DEVELOPMENT FACILITATION TEAM

Planning - Case Comments

Project Number: PR-2023-009368

Project Name: Farolito Senior Community

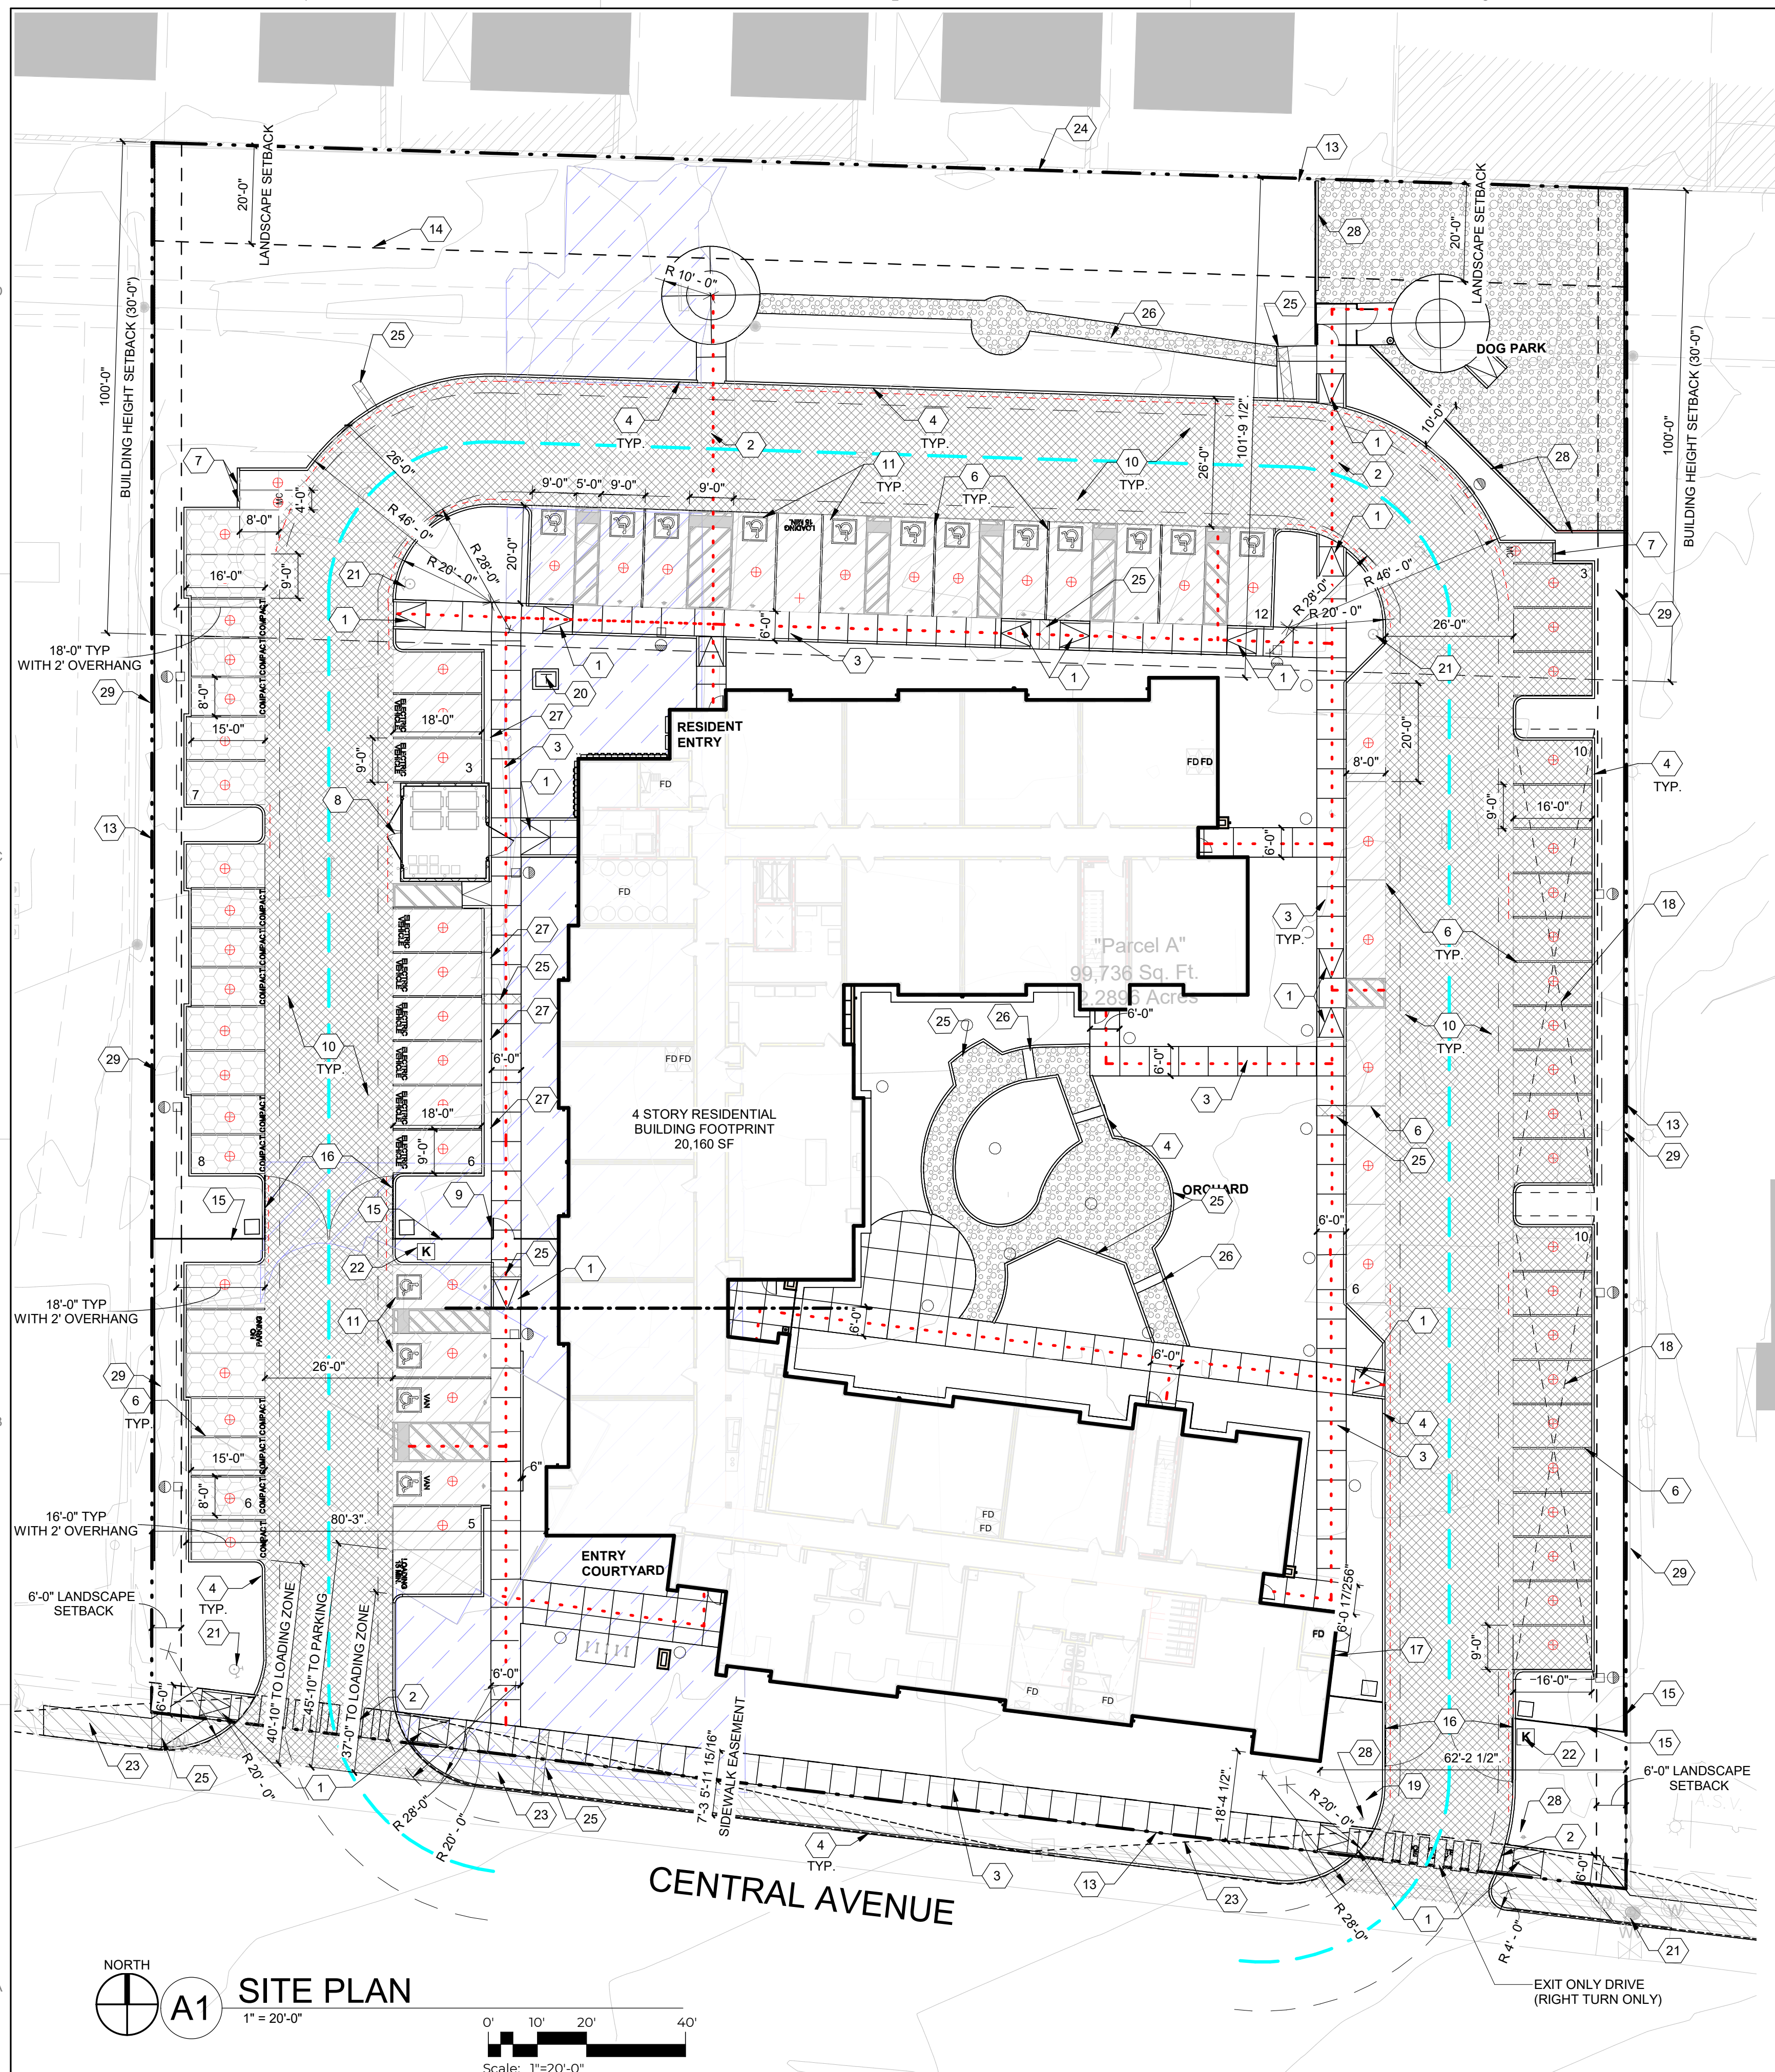
- **Project and application numbers must be added to the site plan set.**
- This site is located within a Major Transit Corridor (MT). Property is not within any UC-MS-PT Areas. Property is not located within any Overlay Zones and Centers.
- The site is located in MX-H Zone. Per 4-2 Allowable Uses, Table 4-2-1, Multi-Family Dwelling is permissive within this zone.
- The applicant confirmed that an Infrastructure List was not submitted with this application.

- IDO 5-5(D) requires motorcycle spaces based on required spaces. **3 motorcycle spaces should be provided. Please identify and specify motorcycle parking.**

- IDO 5-5(E) requires **bicycle spaces based on provided parking spaces.**
 Per Table 5-5-5, 3 bicycle spaces or 10% of required off-street parking spaces, whichever is greater is required. 8 Bicycle spaces are required. 36 total bicycle spaces are provided (18 spaces are indoor and 18 spaces are outdoor) **Please verify how many bicycle pads are provided.**

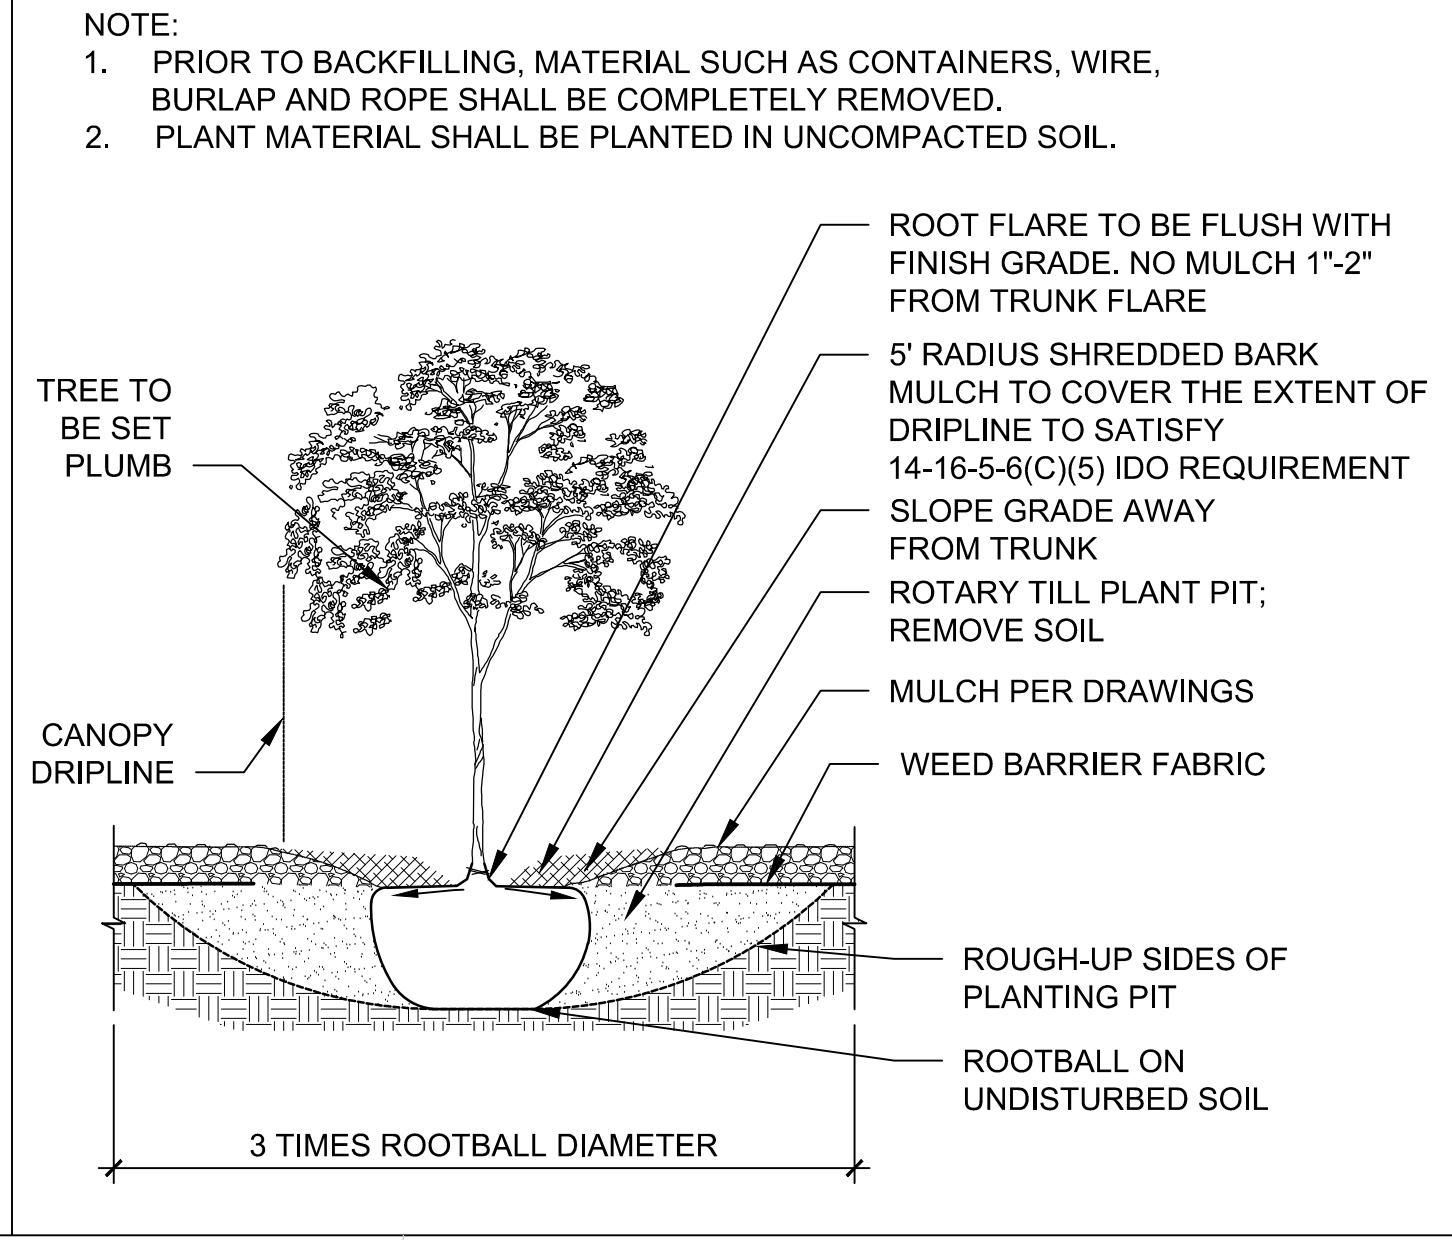
- Please provide an explanation regarding the plant palette and how it complies with 5-6(A)(4).**
 Ensuring the use of native and/or adapted, low water-use, or xeric species and regionally appropriate, sustainable design and maintenance techniques to conserve water resources.
Please provide plant quantities, mature size and level of water consumption on your plant legend.

- Per 5-6(C)(8) The clear sight triangle shall be maintained at all exits of parking areas and street intersections. Keyed note number 4 on the landscape plan articulates complying with this code as follows: “In order to meet clear sight requirements, signs, walls, fences, trees, and shrubs between 3 and 8 feet tall (as measured from the gutter pan) will not be permitted in the clear sight triangle.” *For those plants located in the site triangles, please specify the shrubs’ mature size.*

- Per 5-6(C)(9)(a) All planting of vegetated material or installation of any landscaping, buffering, or screening material in the public right-of-way shall require the prior approval of the City. The property owner shall be responsible for the maintenance, repairs, or liability for all the landscaping placed in or over the public right-of-way. *A note regarding this comment has to be added to the landscape plan General Notes.*

- Per 5-6(C)(9)(b) any trees that overhang a public sidewalk or Major Public Open Space shall be trimmed to maintain an 8-foot clearance over the sidewalk. Any trees that overhang a public street shall be trimmed to maintain a 9-foot clearance over the street surface. *A note regarding this comment has to be added to the landscape plan General Notes.*

- A note is included on the landscape plan to indicate Irrigation plan compliance with IDO requirements.
- Per 5-6(C)(10)(b) trees shall not be planted within 10 feet in any direction of the centerline of a sewer or water line. *A note regarding this comment has to be added to the landscape plan General Notes.*

- *Overhead distribution electric or transmission lines are present on the site, per 5-6(C)(10)(d) please consider moving the trees away from this existing OHU. Please refer to 5-6(C)(10)(d) for more information.*

- *Please consider showing the existing light poles along the frontage of the site and show 15’ clearance around those street lights. No tree trunk should be placed closer than 15’ to the light poles.*

- Per 5-6(C)(10)(e), all screening and vegetation surrounding ground-mounted transformers and utility pads must allow 10 feet of clearance for access and to ensure the safety of the work crews and public during maintenance and repair. *Please consider correcting the relevant note on the Landscape plan to match the IDO code language.*

- Per 5-6(C)(10)(f), trees shall not be planted near existing or proposed street light poles. On the proposed landscape plan please consider moving the trees away from the light poles. See figure below as an example:
A note regarding this comment has to be added to the landscape plan General Notes.

- Per 5-6(D)(1)(c), planting areas necessary for trees in the street frontage shall meet the minimum size requirements in Table 5-6-3. Please confirm compliance with this code.

- Per 5-6(F)(2)(c) 3., at least 75 percent of the required parking area trees shall be deciduous canopy-type shade trees, capable of achieving a mature canopy diameter of at least 25 feet. Please confirm compliance with this code.

- Per 5-6(F)(2)(d) 1., The minimum size of tree planters within off-street parking areas shall be 60 square feet per tree. Please show area of parking lot landscape areas to show compliance with this code.

**TREE PLANTING DETAIL**

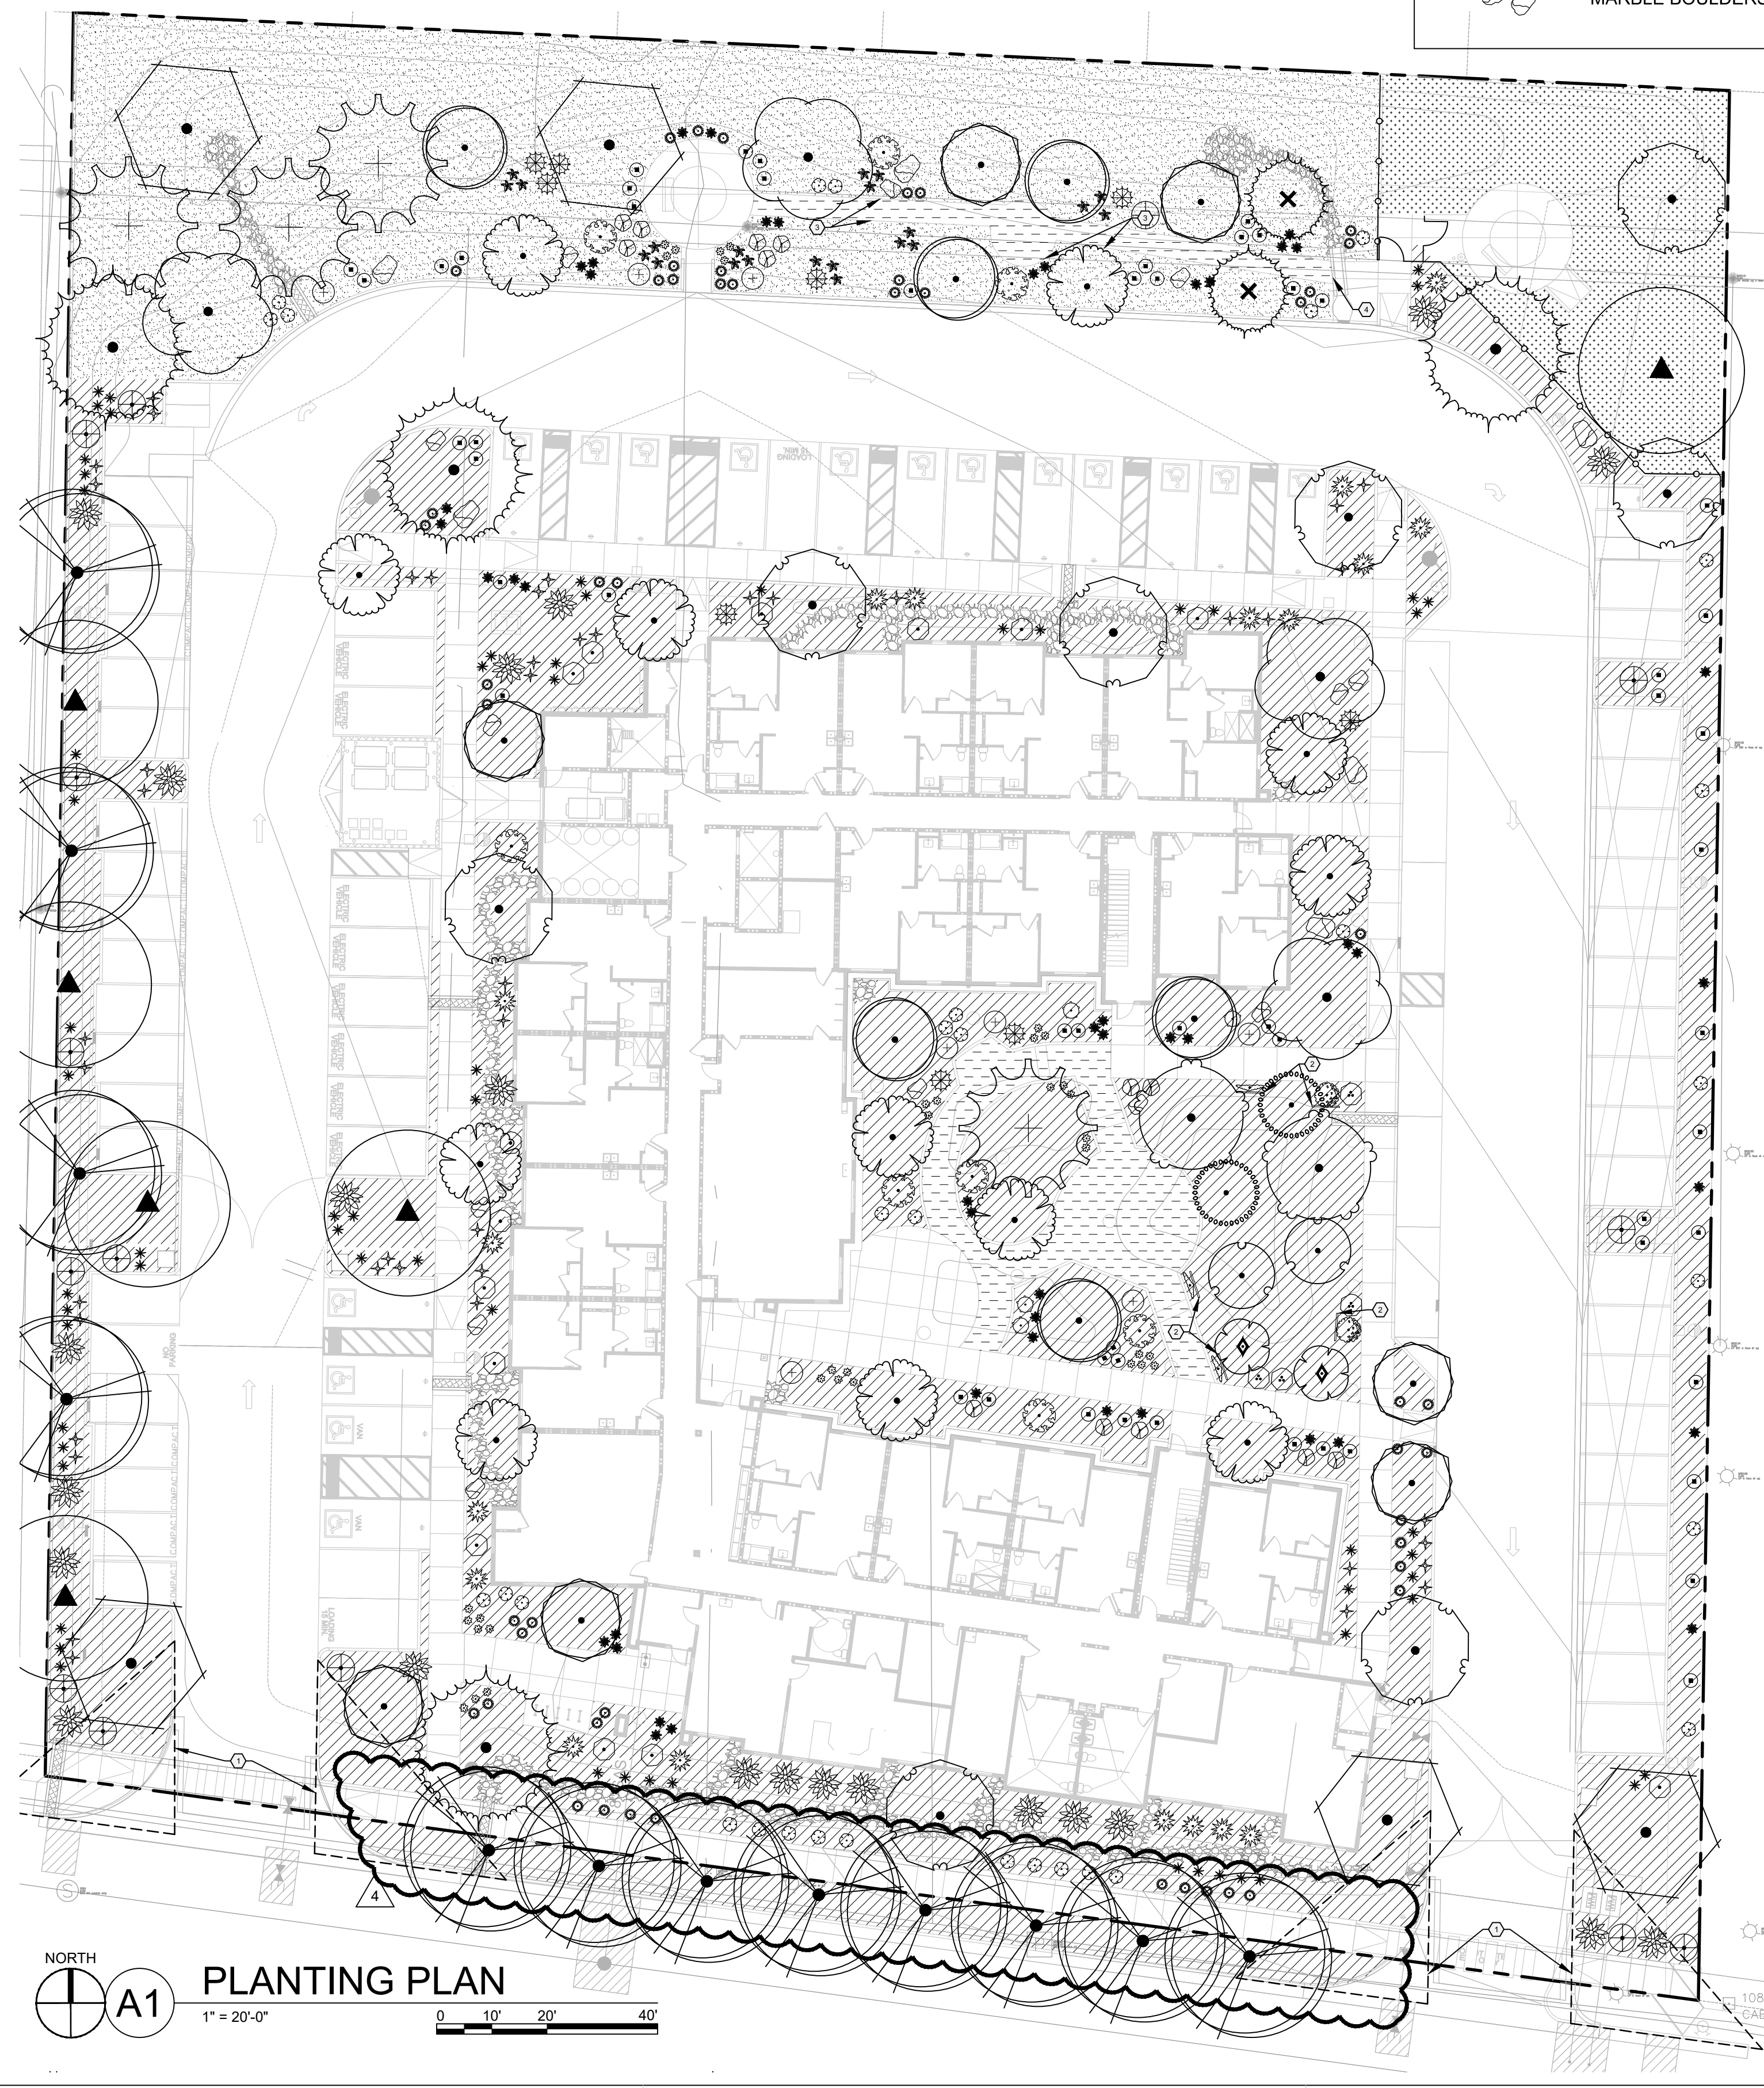
- Per 5-6(C)(5)(e) Organic mulch is required as ground cover under trees within a 5-foot radius around the tree trunk, but not directly against the trunk. In these areas, weed barrier fabric is prohibited. Please correct tree planting detail to show a 5-foot radius bark mulch around the tree trunk. Please remove the weed barrier extension from this 5-foot radius area. Please see below:
